From: Simon Davis
Sent: 20 March 2019 10:09
To: Karen Parsons
Cc: Laura Gibbons
Subject: FW: BN/50/18/PL The Fallows

"We would not wish to allow construction to commence prior to surface water drainage design being formally agreed. This is due to the fact that surface water drainage should be one of the first elements constructed. Alterations to design of the drainage could have significant knock on impacts upon wider construction. Therefore, if the application is to be determined immediately we would recommend you refuse this application."

Drawing 23B – SW Drainage Plan
Scale 1:200 @ A3

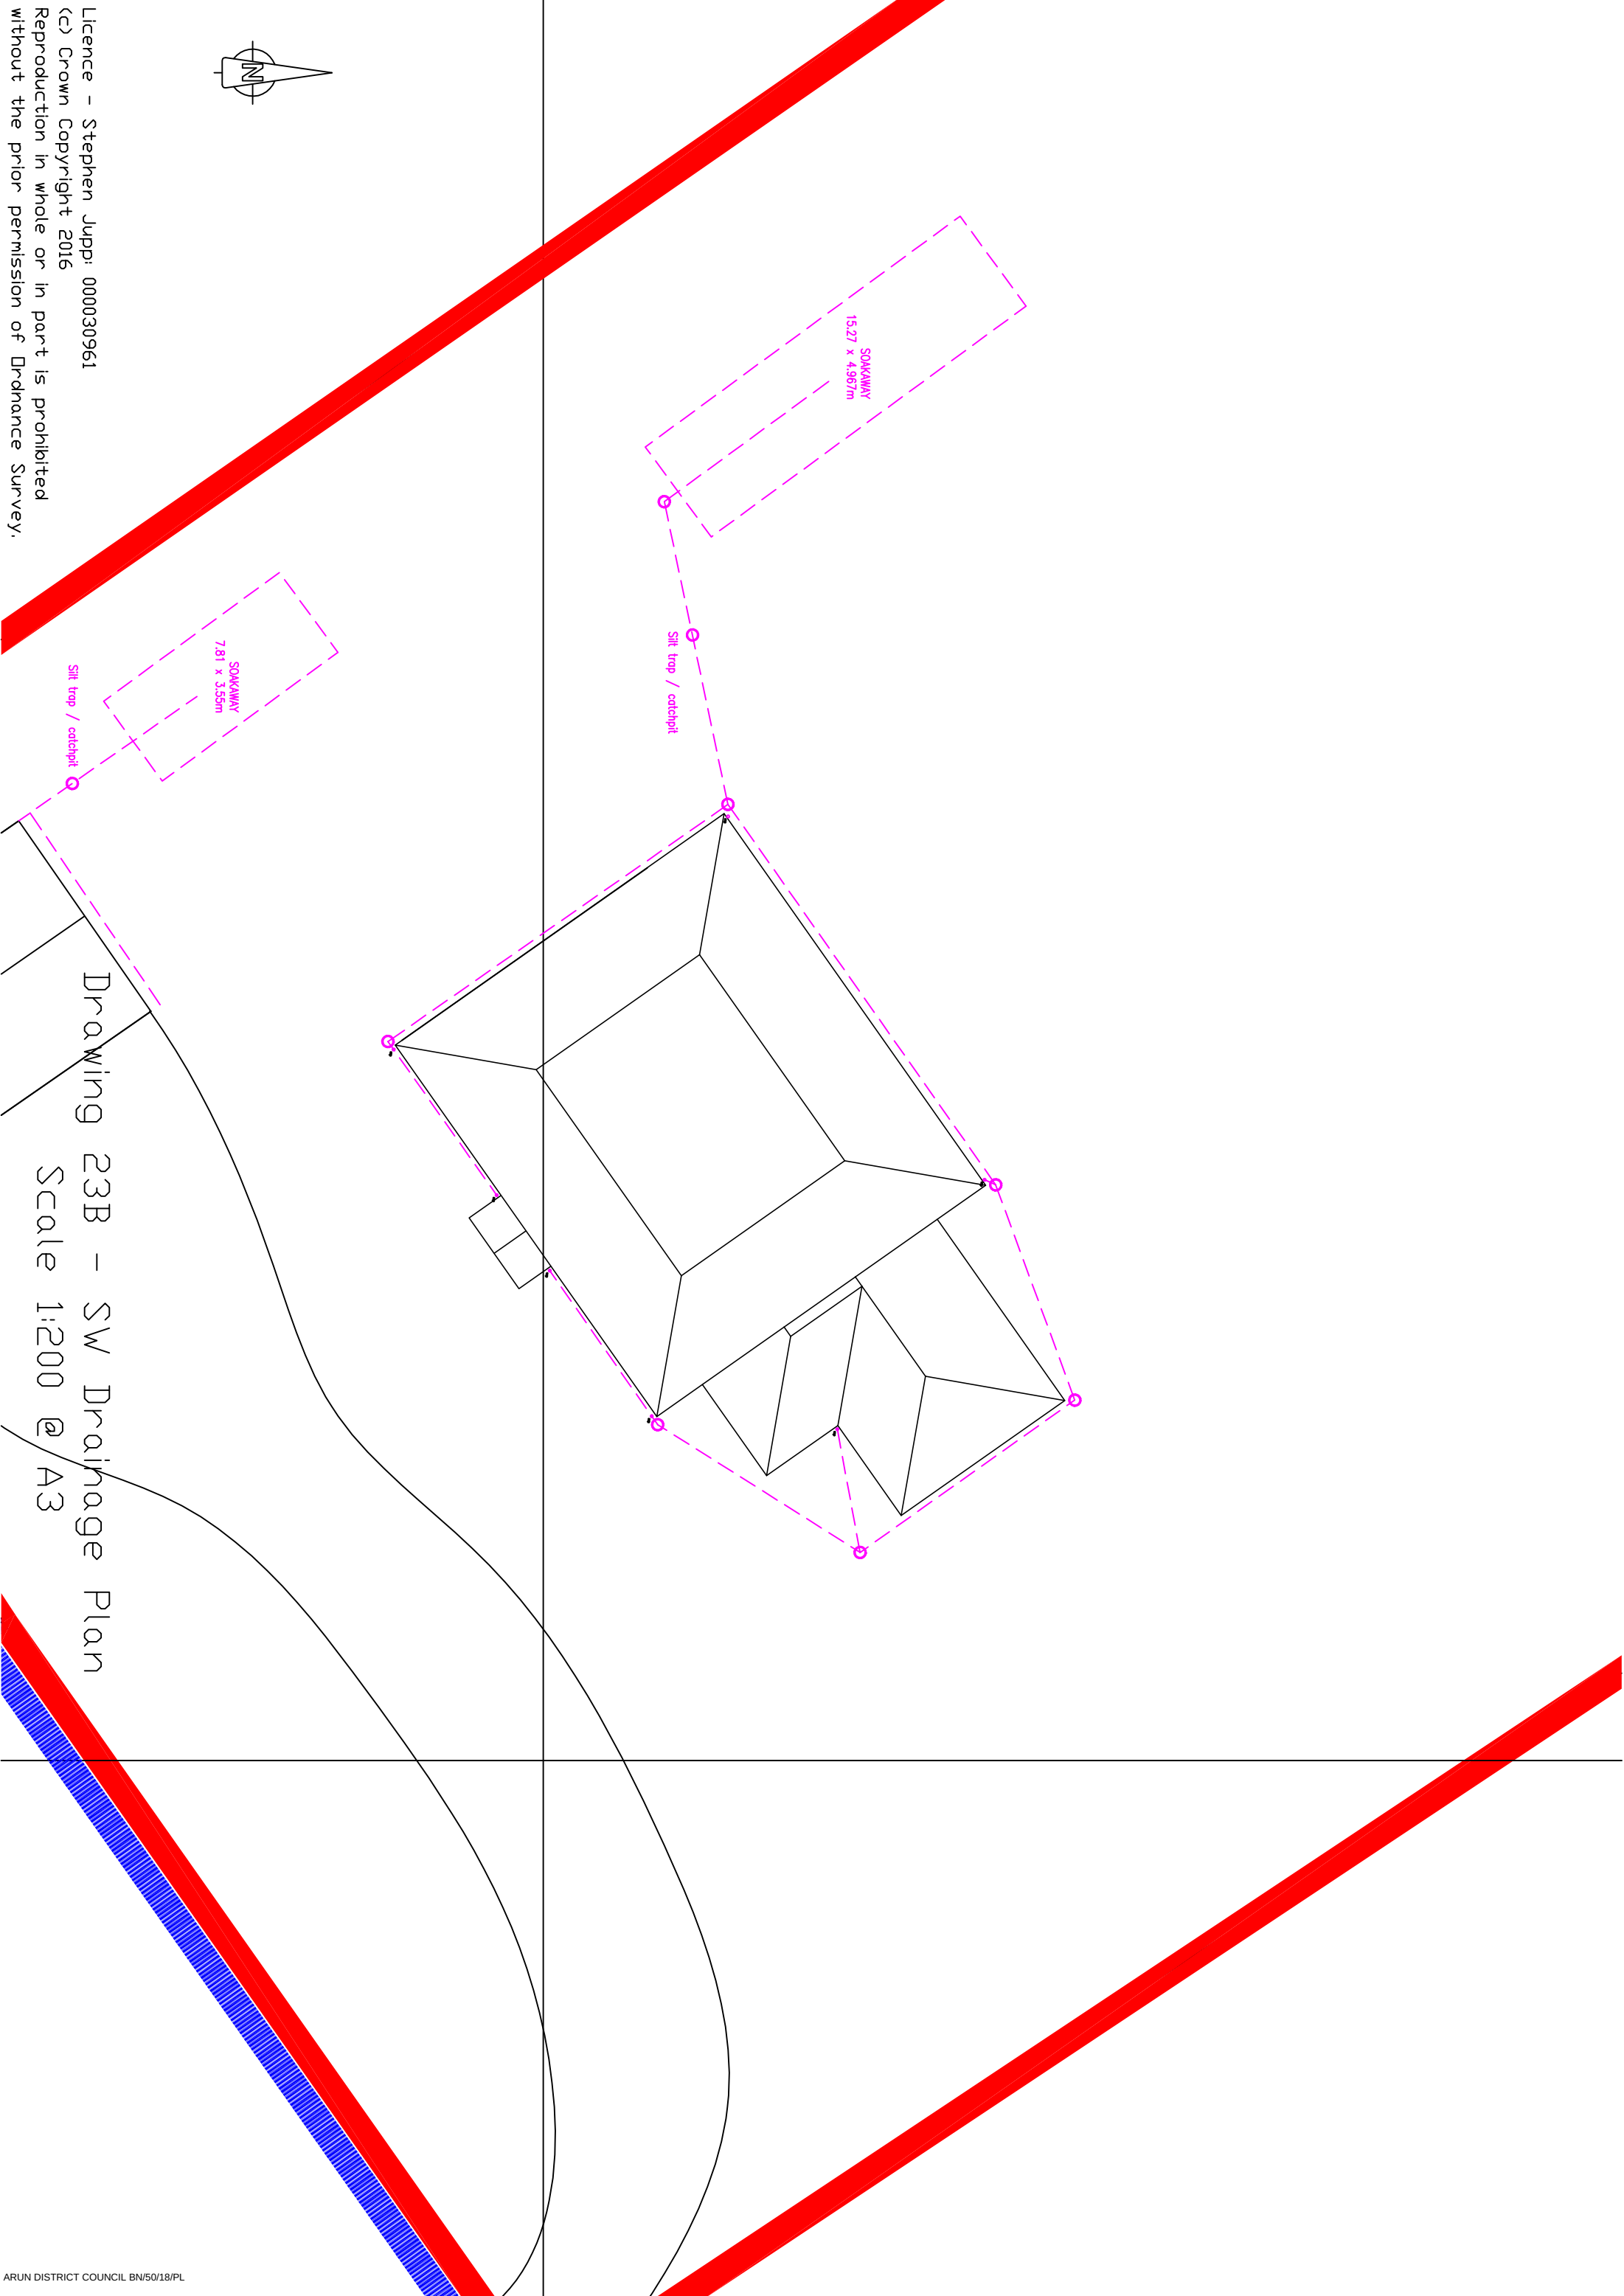
I provided my initial comments to this application in November stating our requirement for winter groundwater monitoring and infiltration testing. Since this time there has been ample opportunity for the applicant to complete groundwater monitoring and infiltration testing. Infiltration testing has been completed and it appears that groundwater monitoring is being undertaken. However, without the groundwater monitoring results we cannot assess if the proposed design is adequate. If the determination of this application is delayed by a couple of weeks I hope that the groundwater monitoring results can be provided and my request for this condition be removed. I believe this would be the most efficient way forwards."

It is unclear from the supplied information if three consecutive infiltration tests were completed as is required. The information also states that a piezometer was installed to monitor ground water levels. These ongoing monitoring results have not been provided.

Please find attached details of the soakaway design and infiltration results.
Groundwater level monitoring will continue until March and I would suggest that those results can be conditioned.
